**Table 1 Authority comments and Elton Consulting's responses**

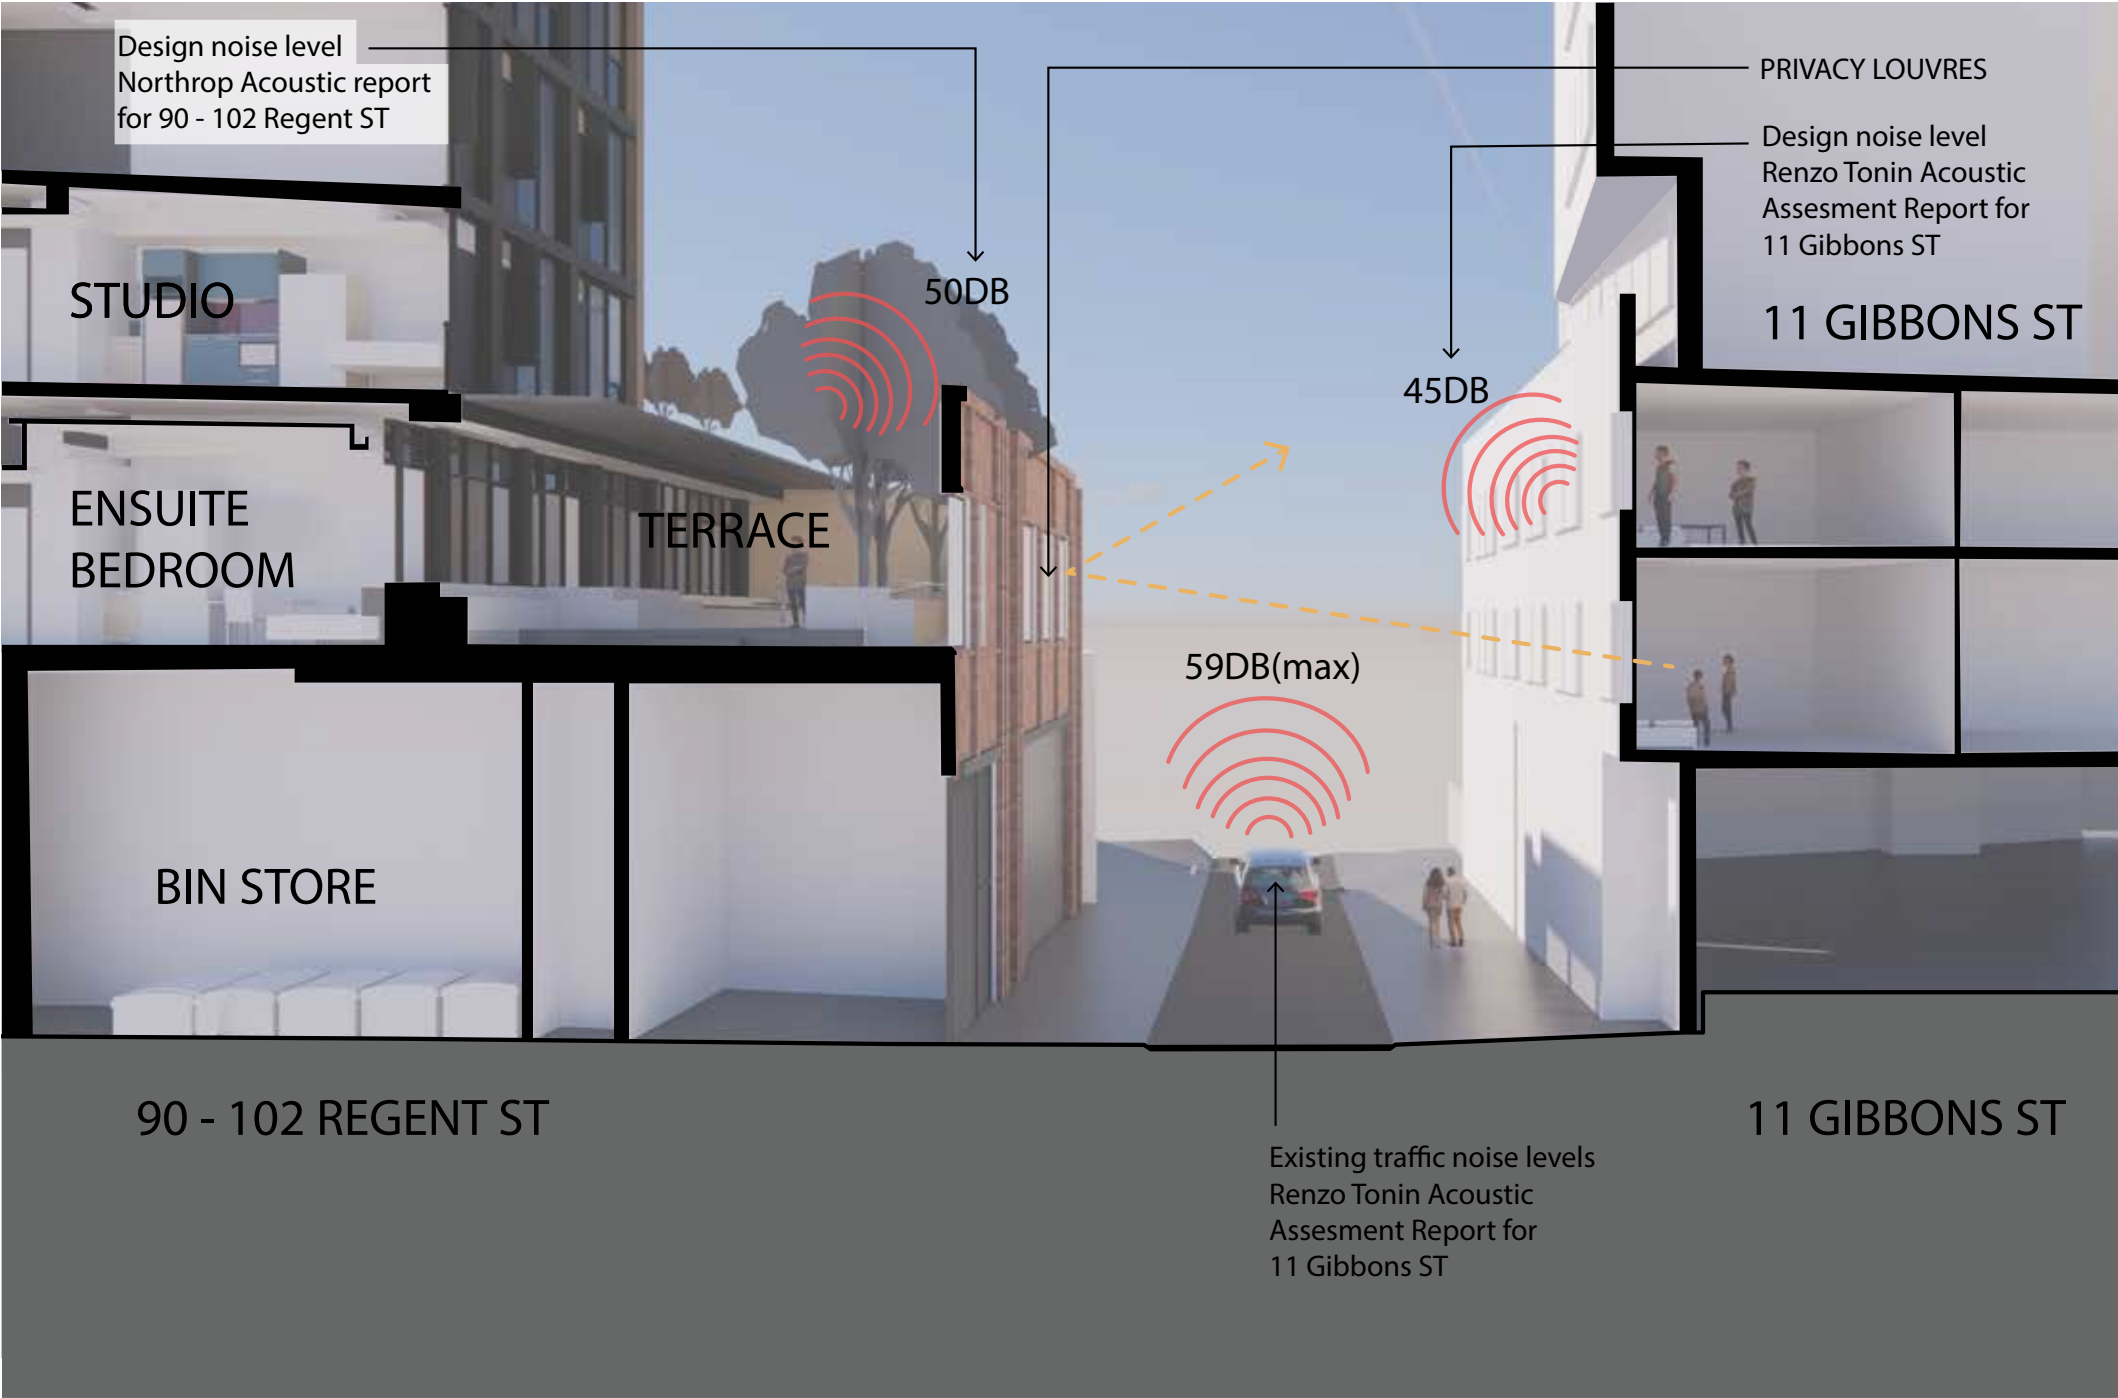
View and visual privacy impacts on SGCH development.	Western facade is set back 18m, compliant with ADG guidelines. At Level 2 western terrace, openings incorporate privacy louvres, redirecting any views towards SGCH development. Inside the gym, colour backed glass obscures view into SGCH units.	The proposed development is compliant with controls and every effort has been taken to mitigate effects to views and visual privacy.
Potential safety issues associated with laneways.	Laneway is proposed to become a through site link with spaces designed to activate the street. Bike store and entrance at William Lane will keep this area frequently populated. At 13-23 Gibbons Street development, coffee point and bike store serve similar activation purposes. Laneway is proposed to incorporate artwork, landscaping elements and will continue into Margaret street.	CCTV and lighting will be placed at the entry/exist to the building, including along William Lane, to deter any anti-social behaviour.
